Application for a Non-Material Amendment Following a Grant of Planning Permission

Sheridan Road Shops - Crosslinks  
Roof Detail To Courtyards -  
Revised Proposal

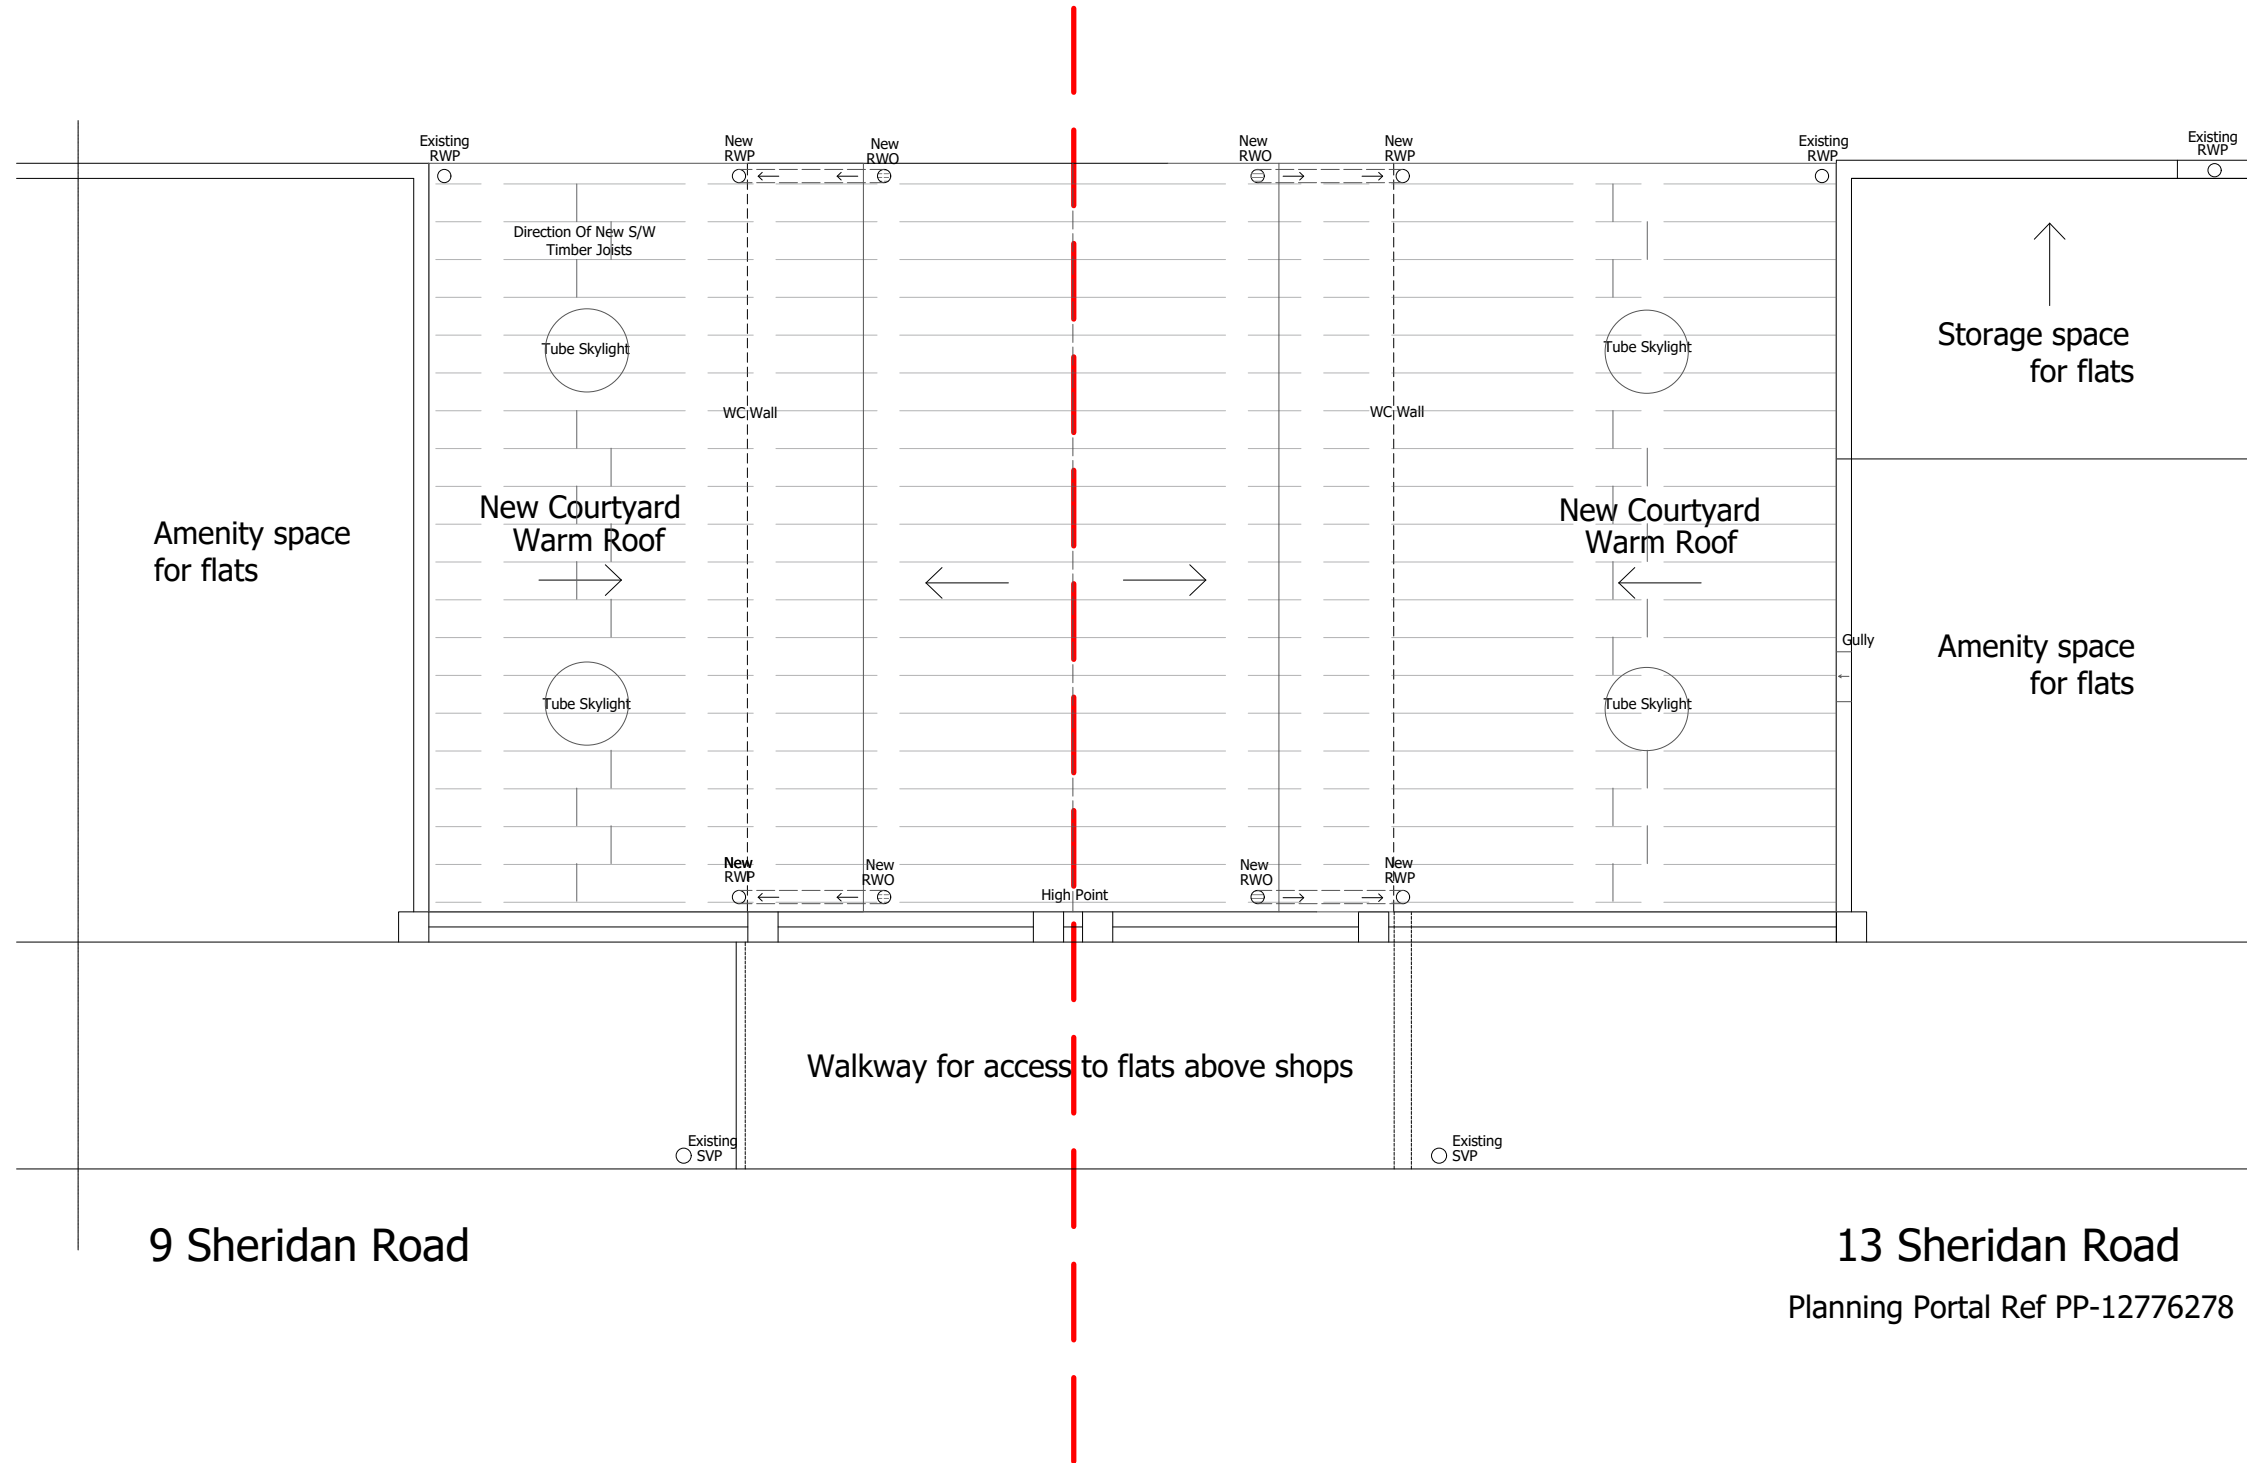
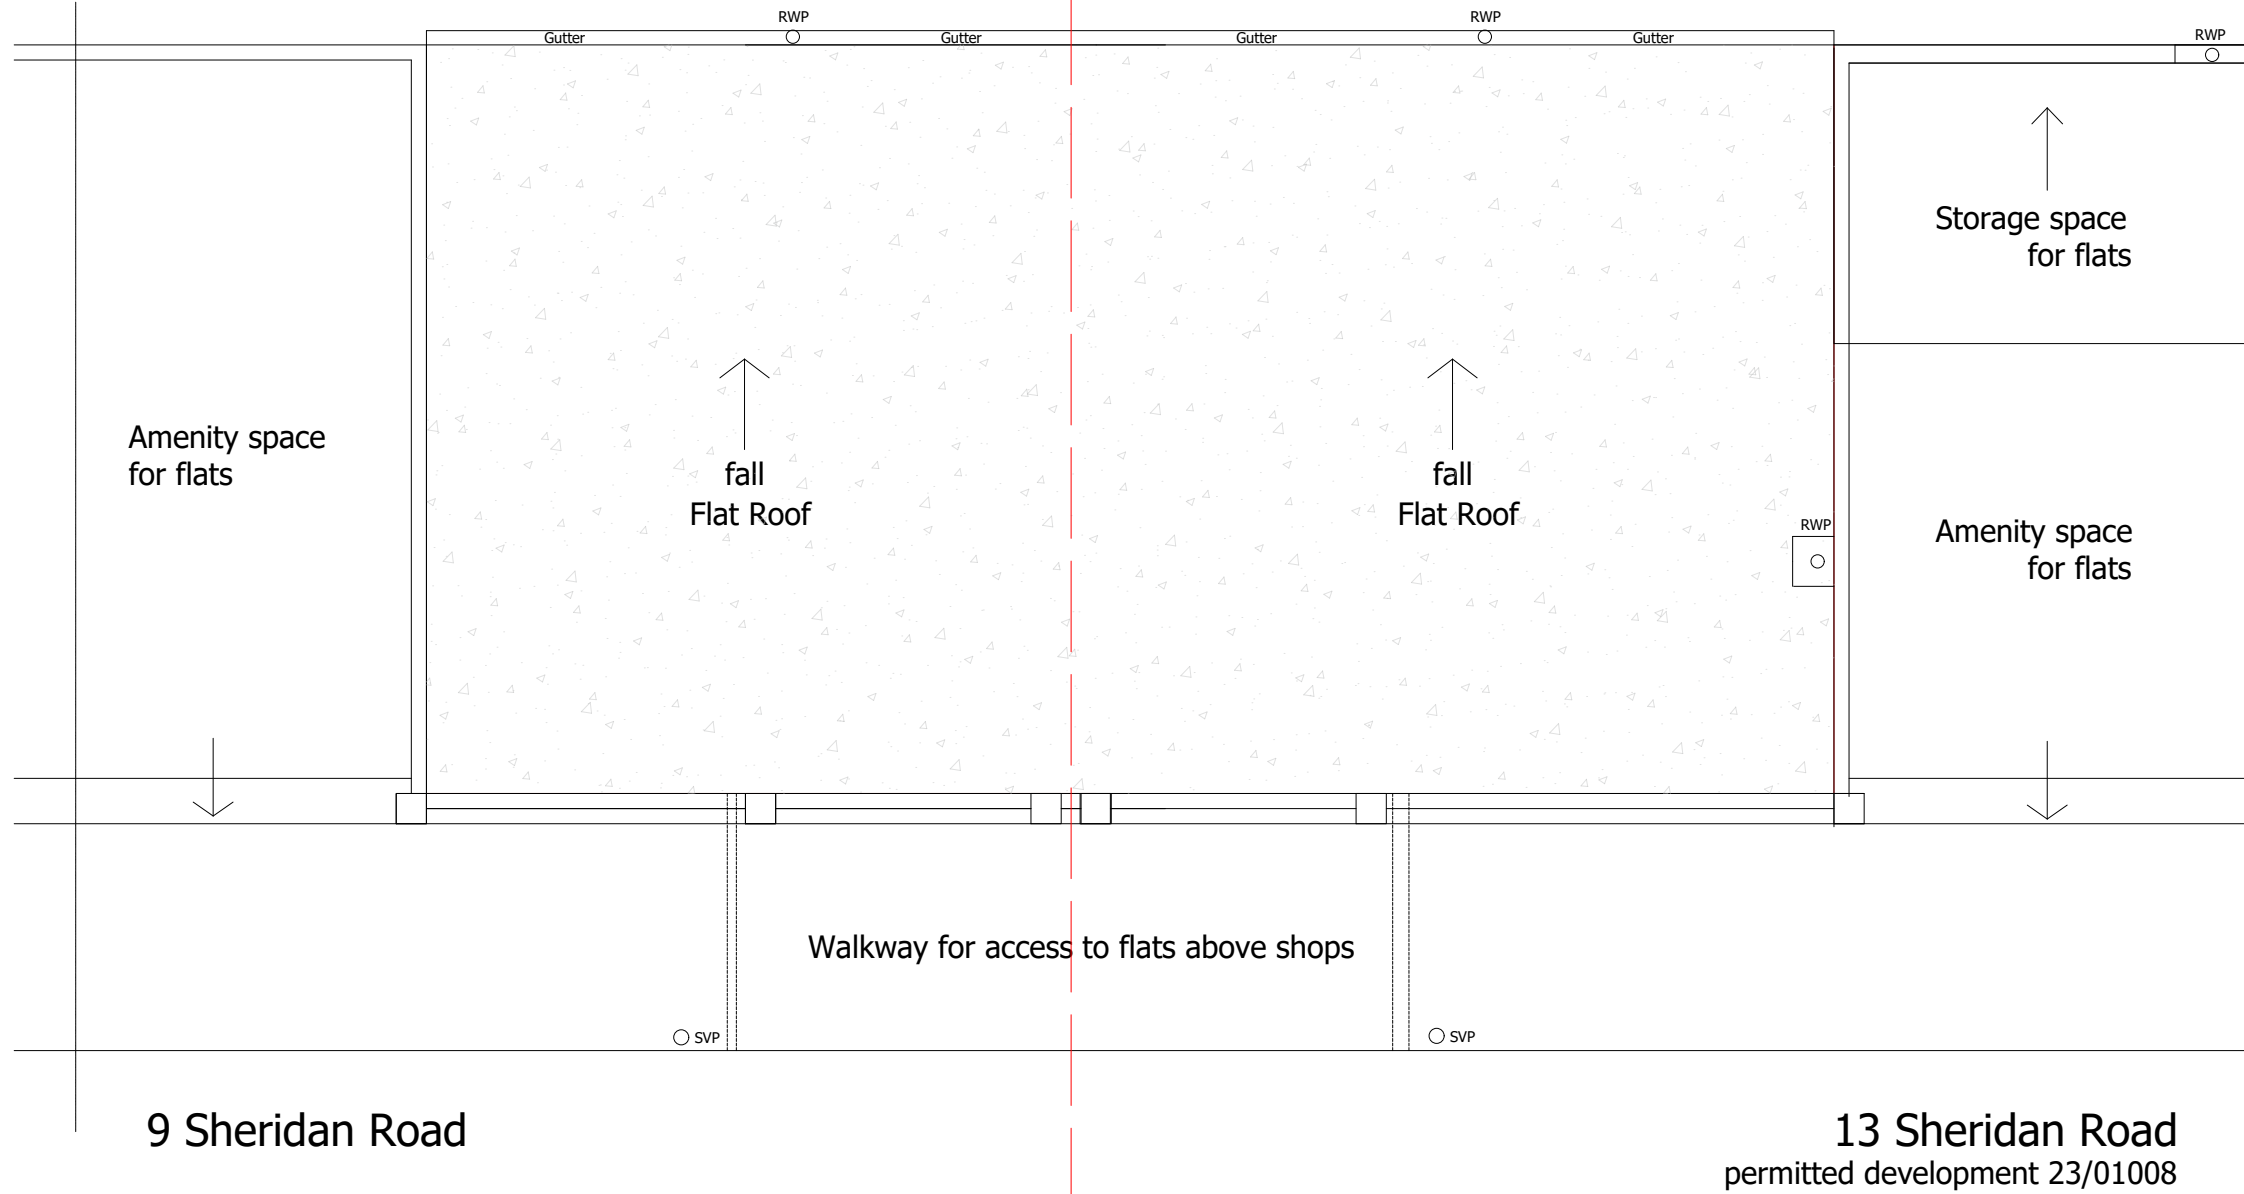
- alterations to required drainage.
- improved rigidity of roof structure.
- how the roof will connect with neighbouring property (see application PP-12776278)

Site Plan
Original Proposal for Courtyard Roof - Elevations To Front, Rear and South East - 9 Sheridan Road
Original Courtyard Roof Detail - 9 Sheridan Road
Proposed Amendments for Courtyard Roof- Elevations To Front, Rear and South East - 9 Sheridan Road
Proposed Roof Detail to Courtyards - 9 Sheridan Road
